**Application no: 22/03677/DISC**

**Location:** Land Adj To Promised Land Farm, Wendlebury Road, Chesterton

## **Lead Local Flood Authority**

Objection

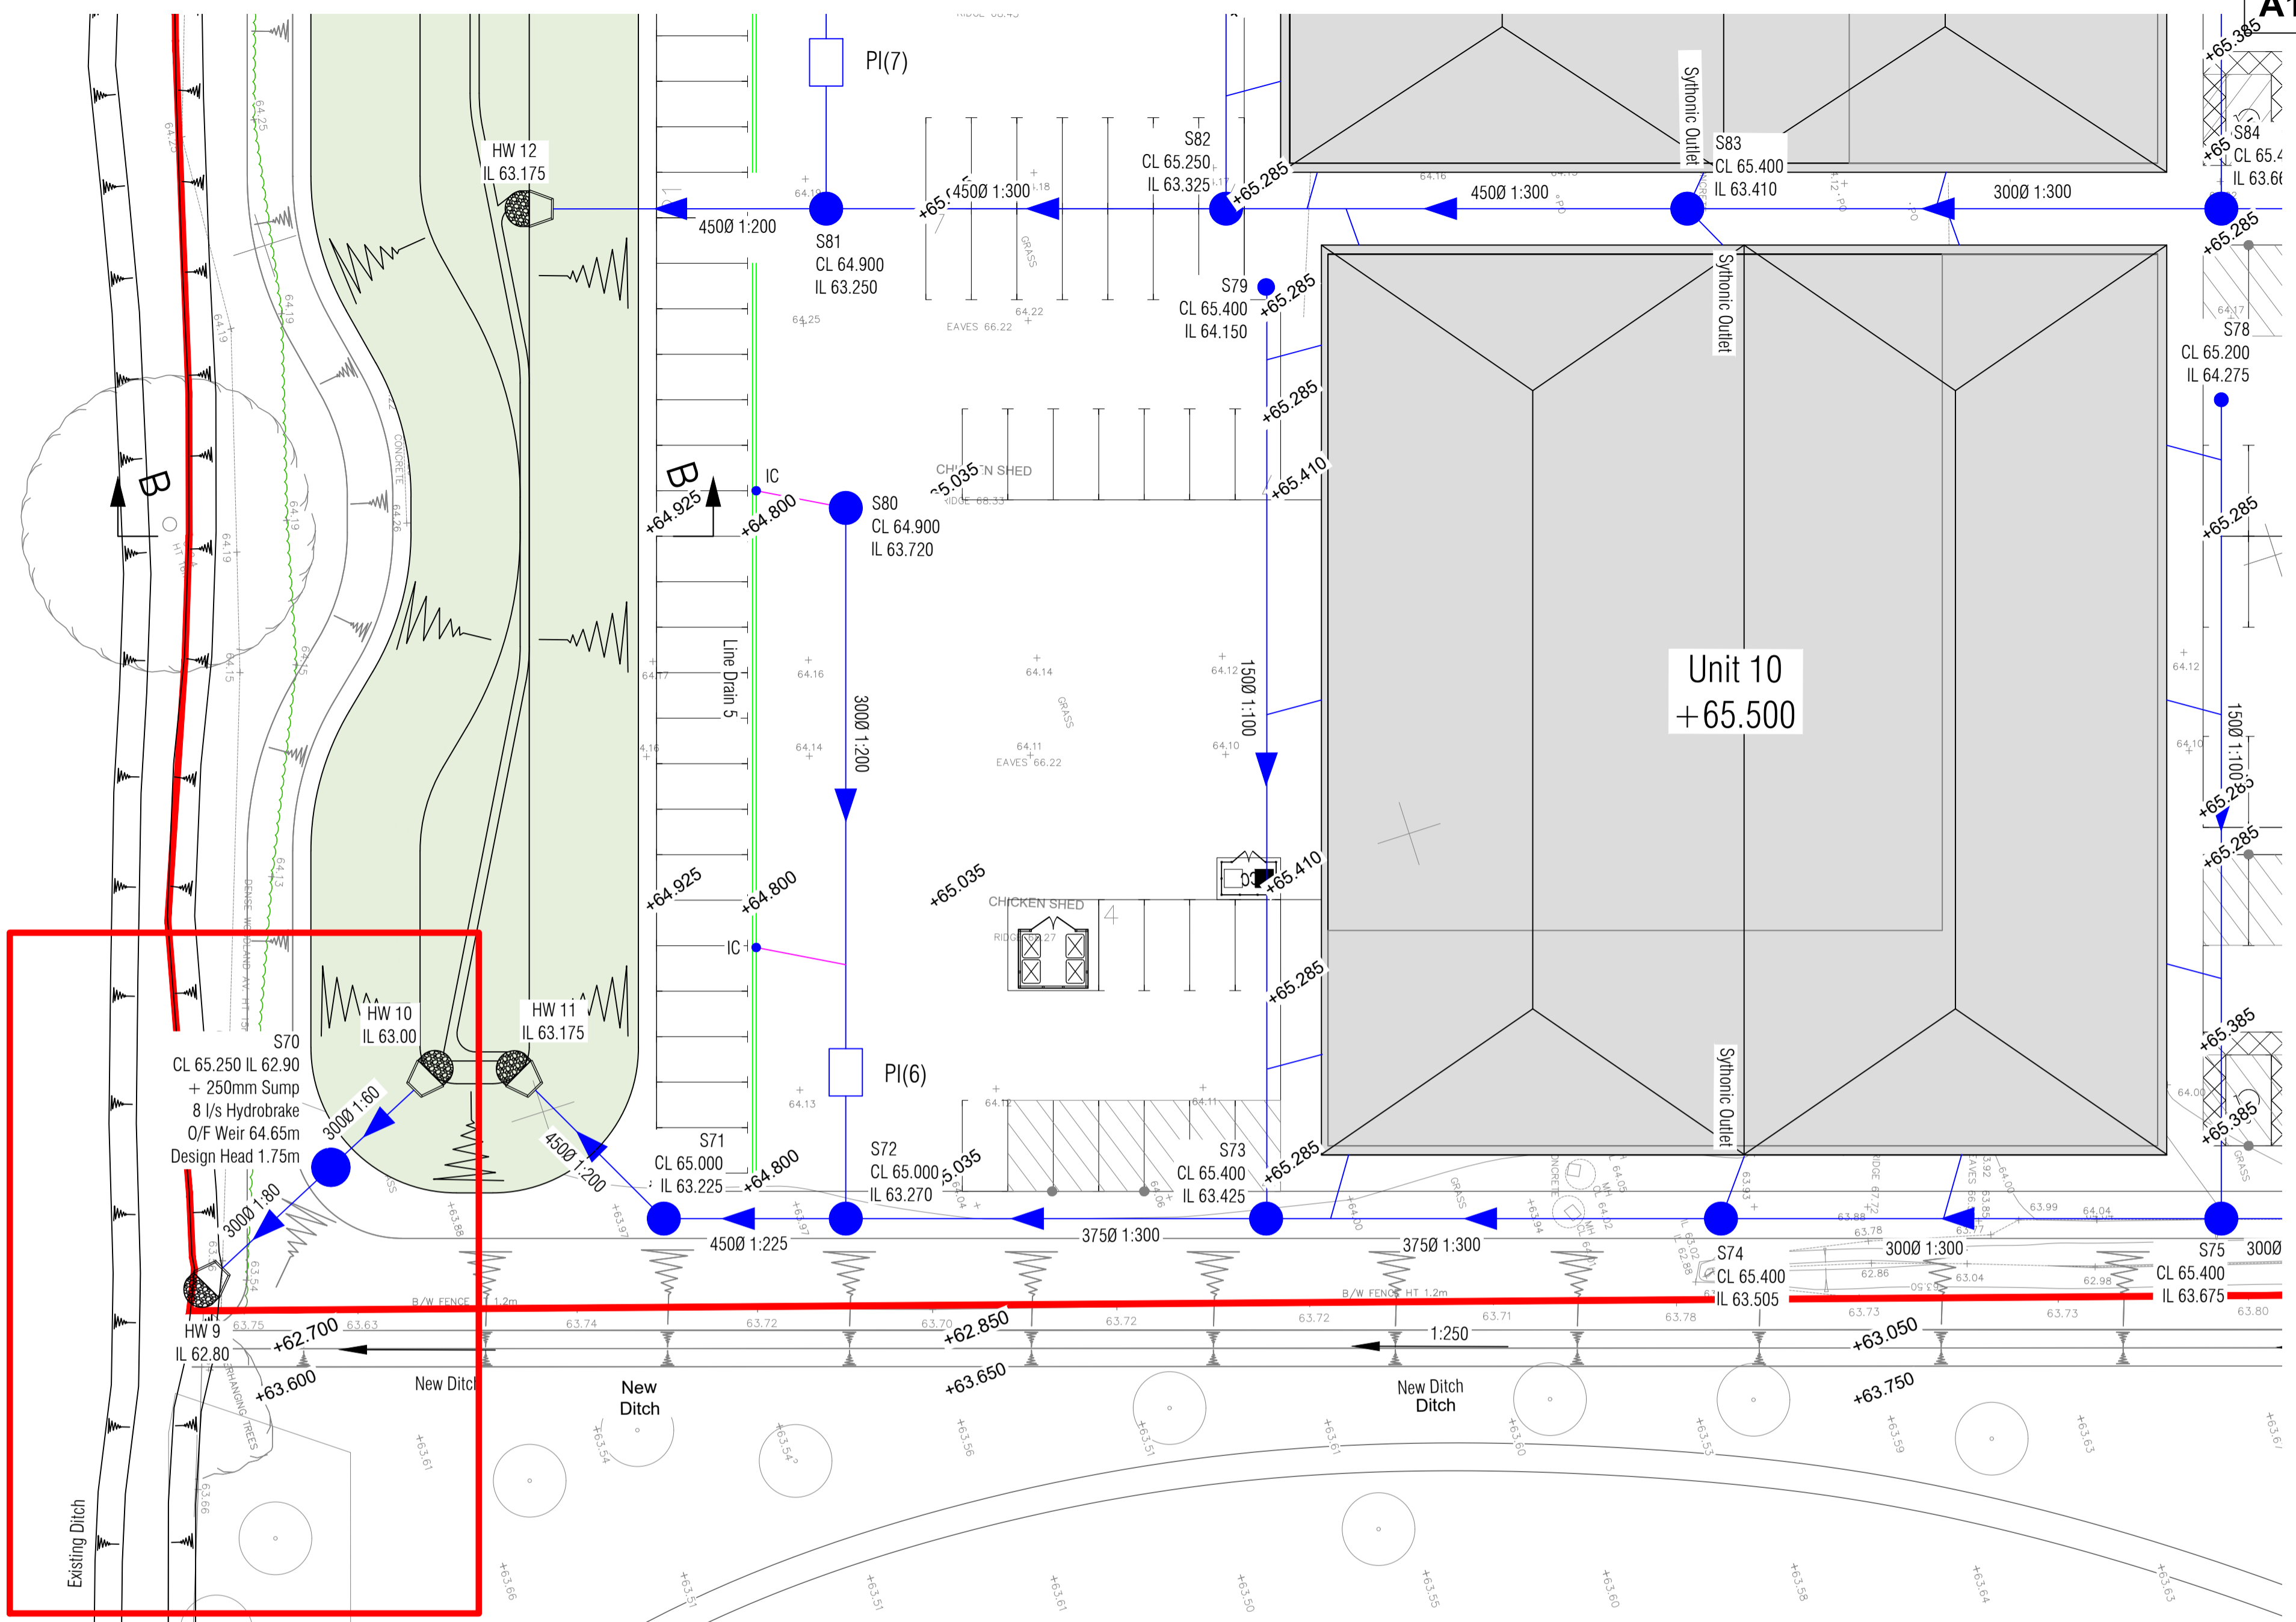
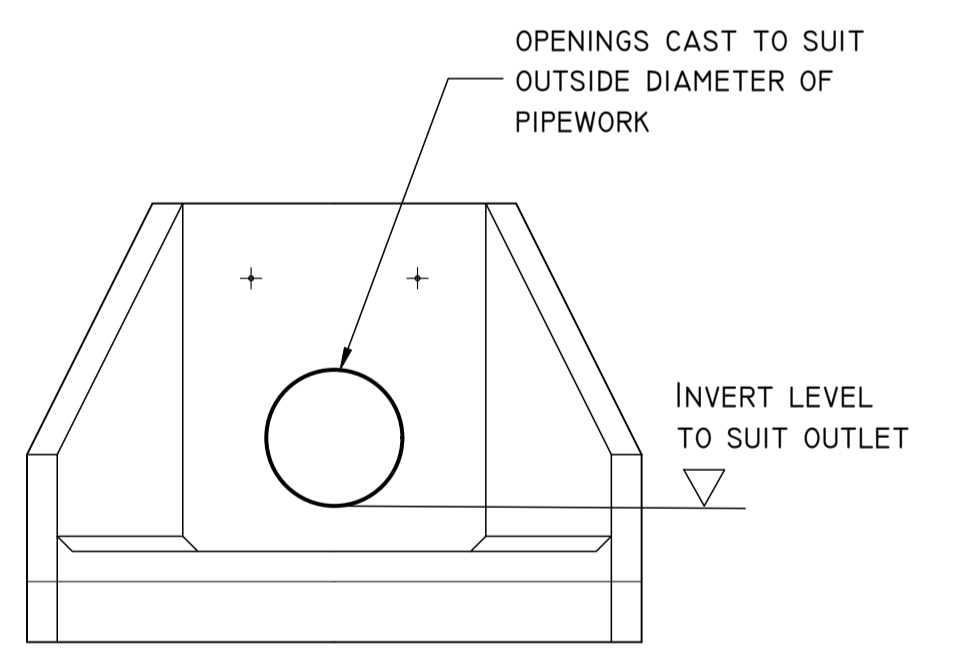
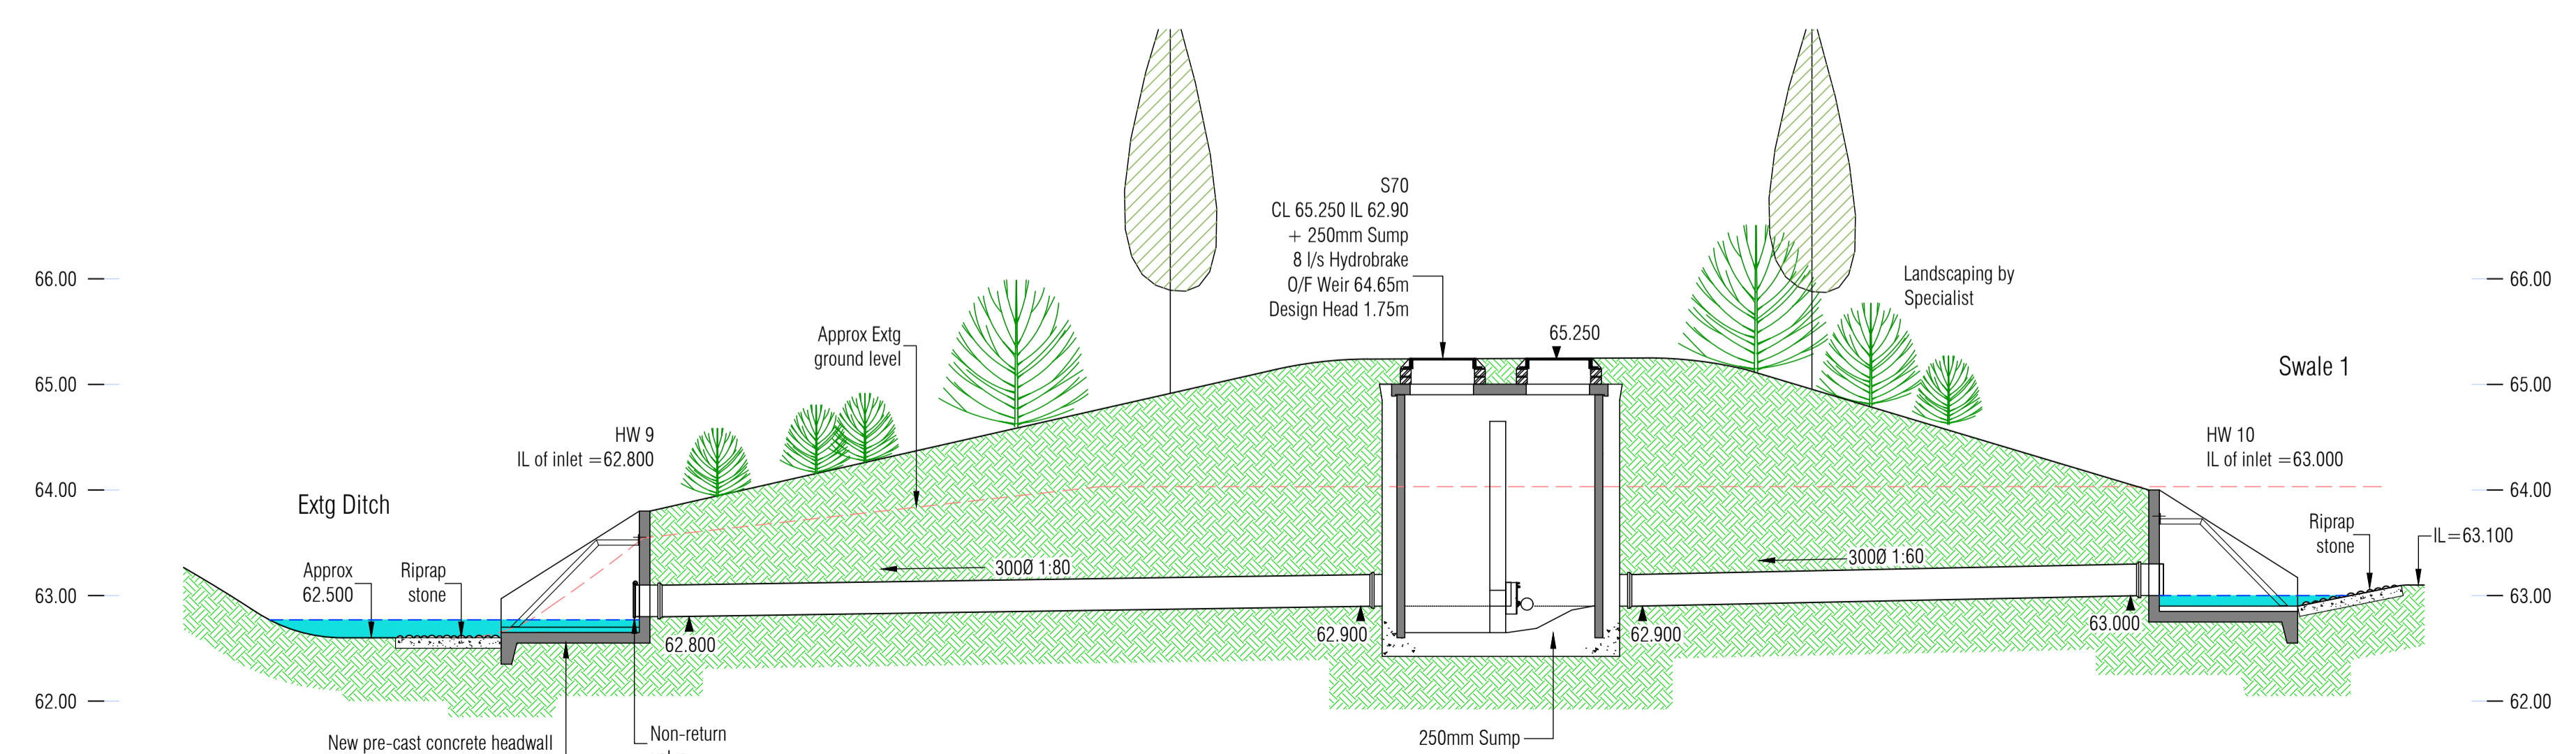
- Provide pipe numbering on the drainage plan which should read in line with the calculations produced.
- Provide SuDS construction details drawings.
- Provide consent to discharge to the existing watercourse. Confirm the capacity of the ditch to take the proposed loads without posing flood risk to the neighbouring sites.
- Provide flood exceedance plan with flood arrows demonstrating that all surface water will be kept away from structures and within the site boundary.
